**Residential Development at 89 John Whiteway Drive, Gosford-Mod-1 (SSD-10321-Mod-1)
Request for additional information**

ATTACHMENT A – RESPONSE TO SUBMISSIONS AND REQUEST FOR INFORMATION

1. DPE Water – Ground Water Assessment

DRAWING TITLE
BASEMENT

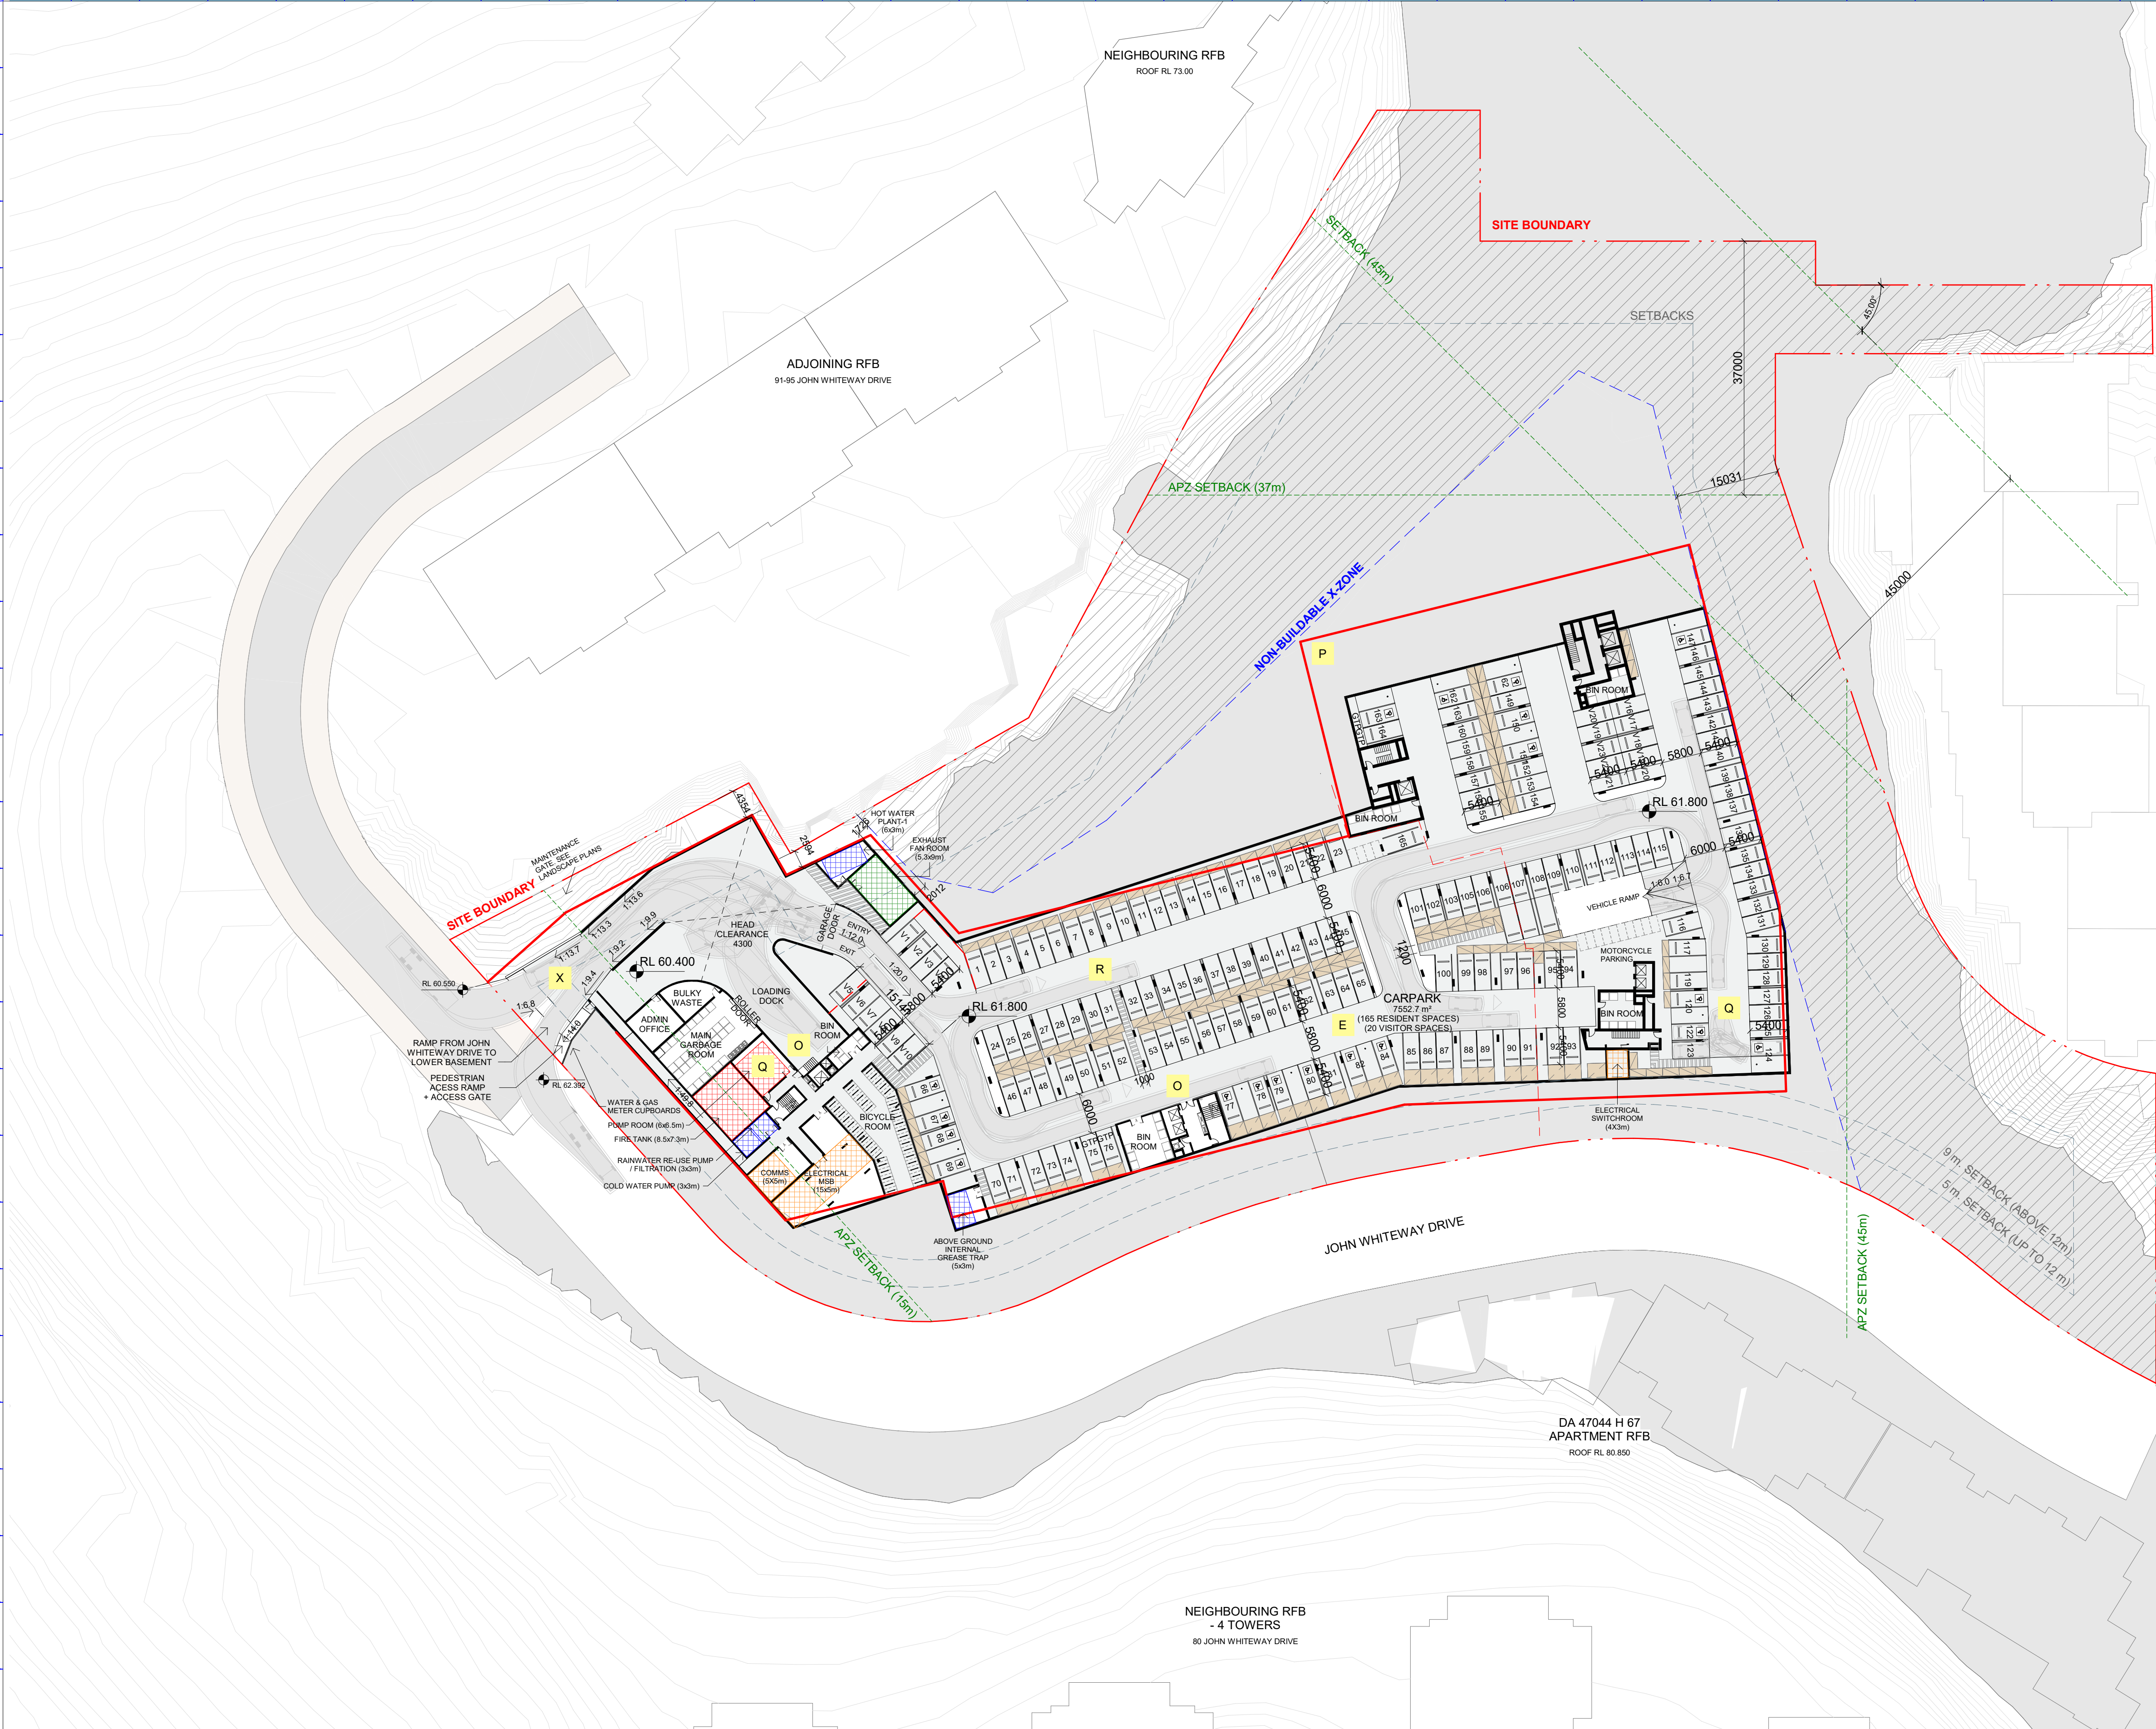
The Department requests that you provide suitable information to address the issues raised in the submission from DPE Water dated 16 February 2022 (copy enclosed). The submitted modification report has not provided an assessment of the impacts on ground water in flows arising from the increased excavation of the basements levels.
